## **PL/2022/00371/PPFL**

Address: Stable Building Oldwich Lane East Fen End Solihull CV8 1NR

Proposal: Erection of replacement stable block, detached barn, new green house and new three bedroom bungalow.

Name: Councillor Balsall Parish Council

A  
1 Location Plan  
1:1250

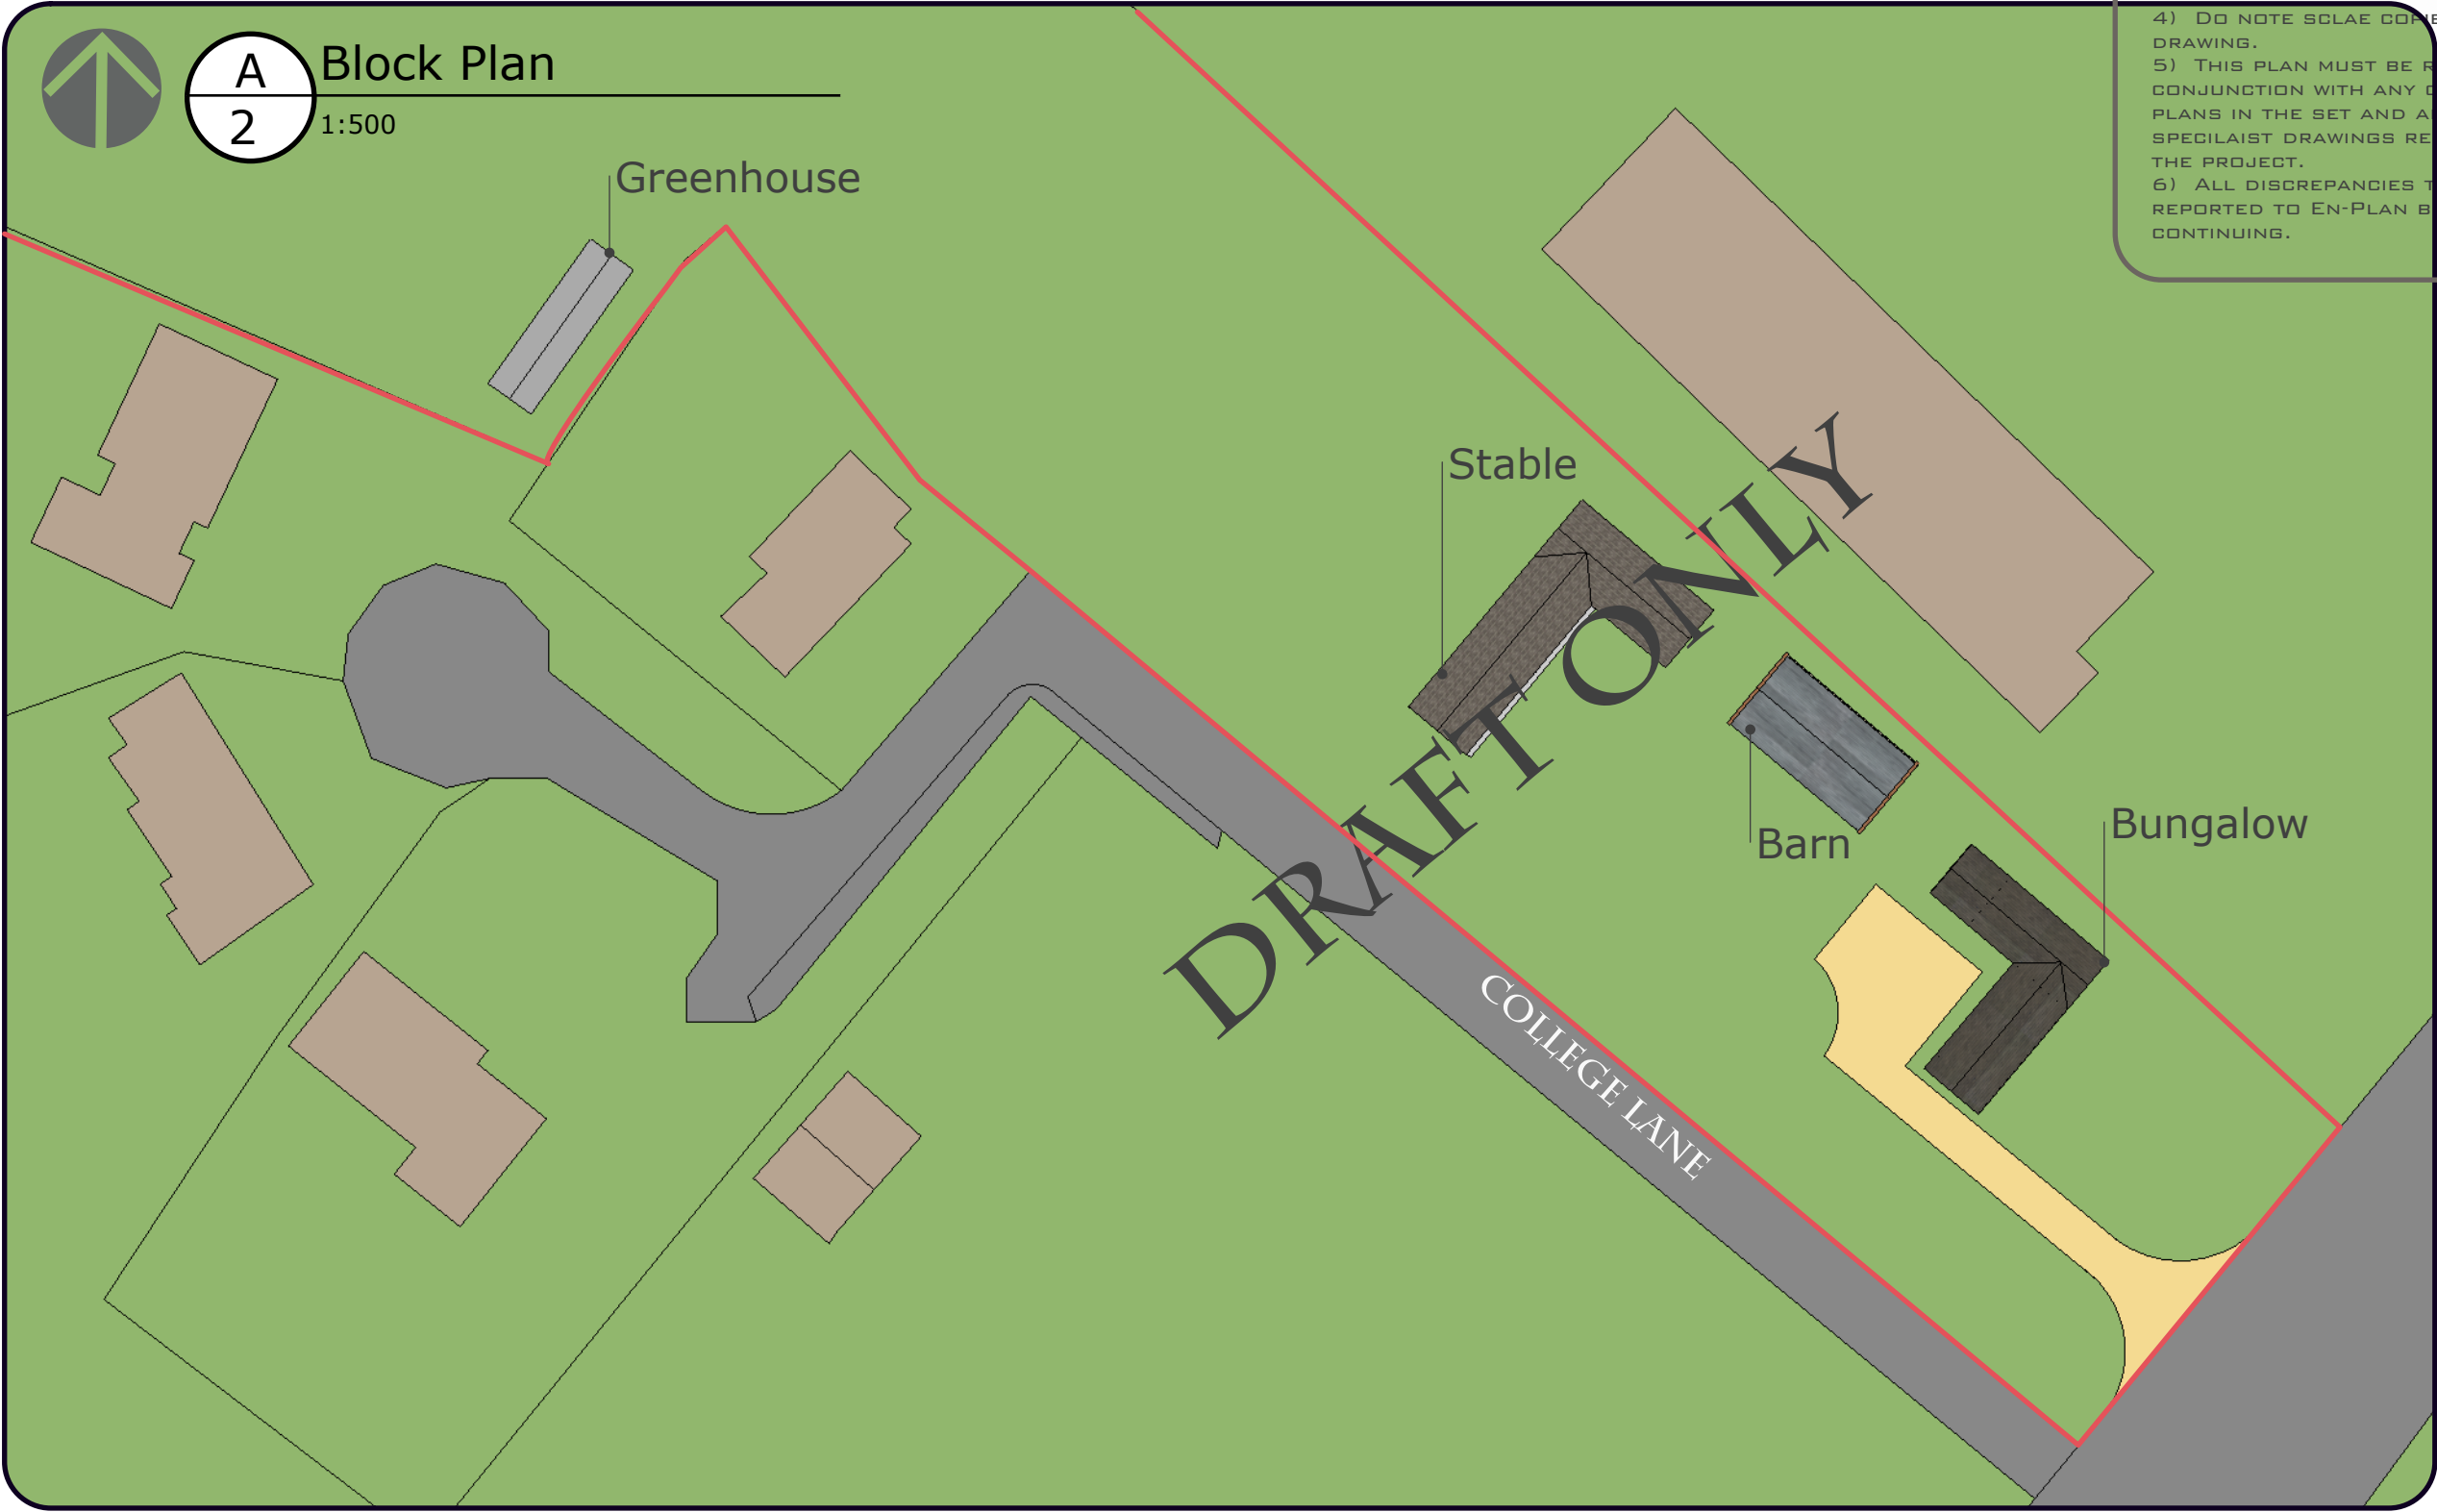
The existing and proposed plans do not show the 3 existing footpaths, nor is the existing timber store shown on the plan (did it require planning permission?). The council is surprised that this was not picked up during the verification process.
